# HERTFORDSHIRE ECOLOGY

Ask for: Neil Harvey  
Tel: 01992 555220  
Date: 18/01/2018

**Application Reference: 6/2017/2964/MAJ**

**Proposed development at: Blue Moon Paddock Woodfield Lane Brookmans Park AL9 6JJ**

Survey Plan with suggested mitigation for reptiles

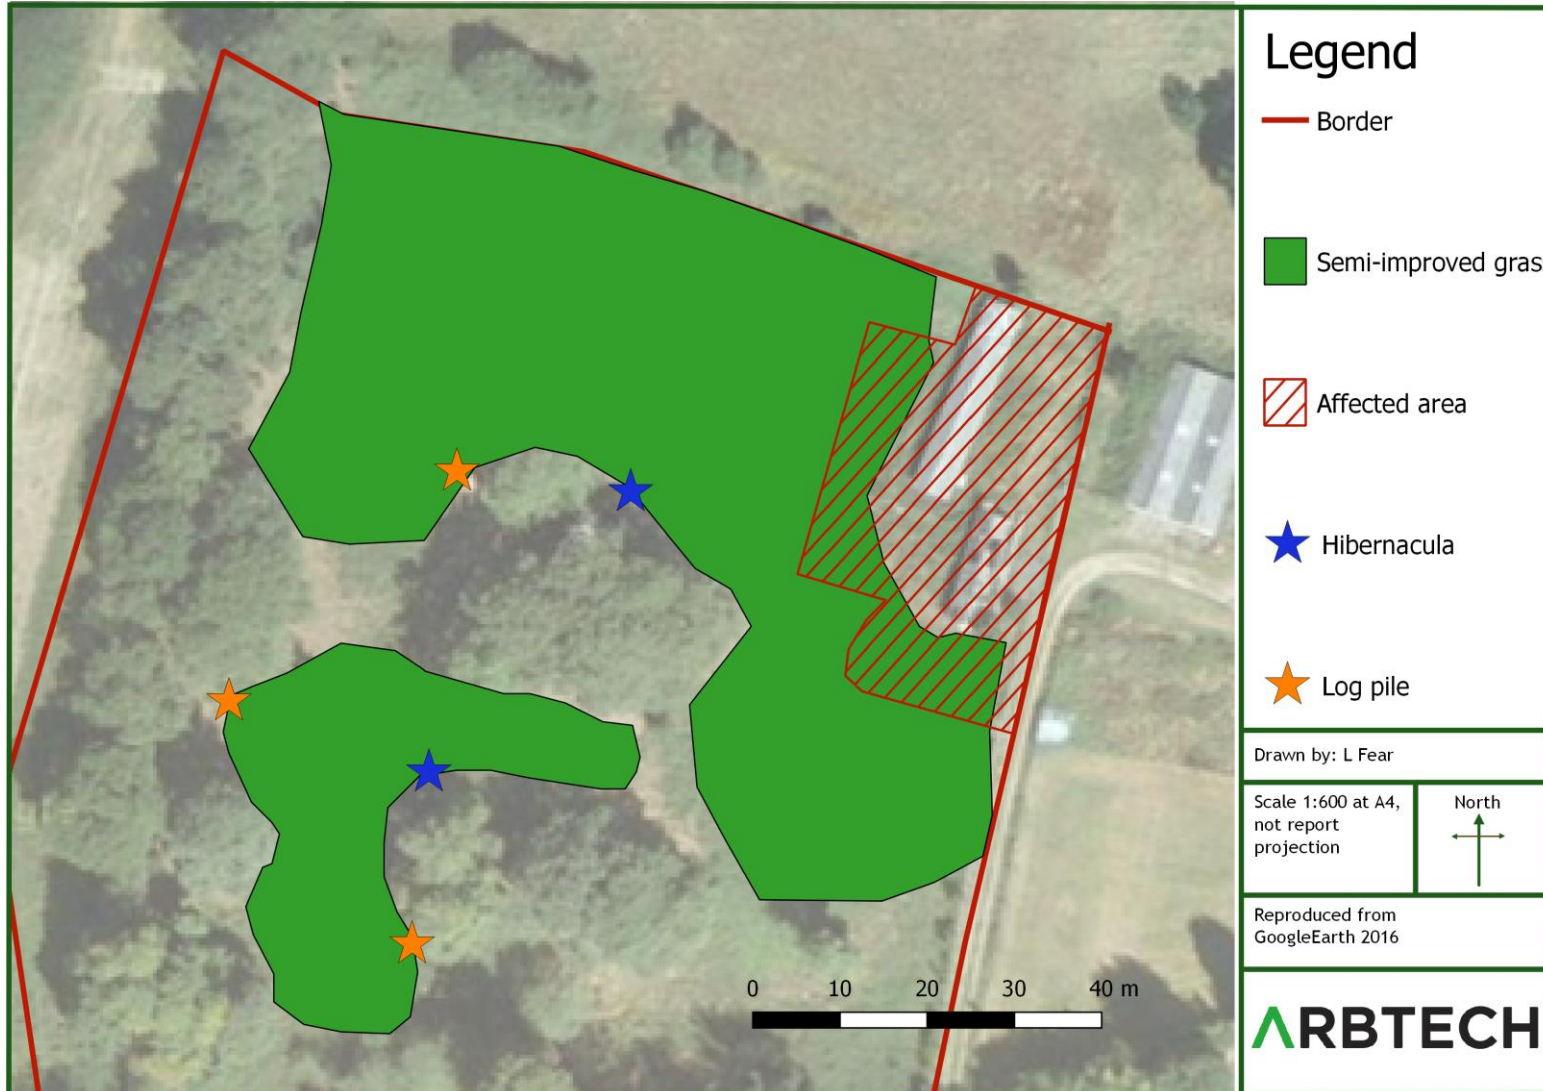
The presence of reptiles on the site has been established and so mitigation measures will be needed in line with those provided within the reptile survey document. It is recommended that this mitigation is secured by means of a **pre-commencement condition**:

*No development shall take place (including any demolition, ground works, site clearance) until a method statement for reptile mitigation has been submitted to and approved in writing by the local planning authority. The content of the method statement shall include the:*

- a) purpose and objectives for the proposed works;*
- b) detailed design(s) and/or working method(s) necessary to achieve stated objectives (including, where relevant, type and source of materials to be used);*
- c) extent and location of proposed works shown on appropriate scale maps and plans;*
- d) timetable for implementation, demonstrating that works are aligned with the proposed phasing of construction;*
- e) persons responsible for implementing the works;*

*The works shall be carried out strictly in accordance with the approved details prior to the commencement of construction works.*
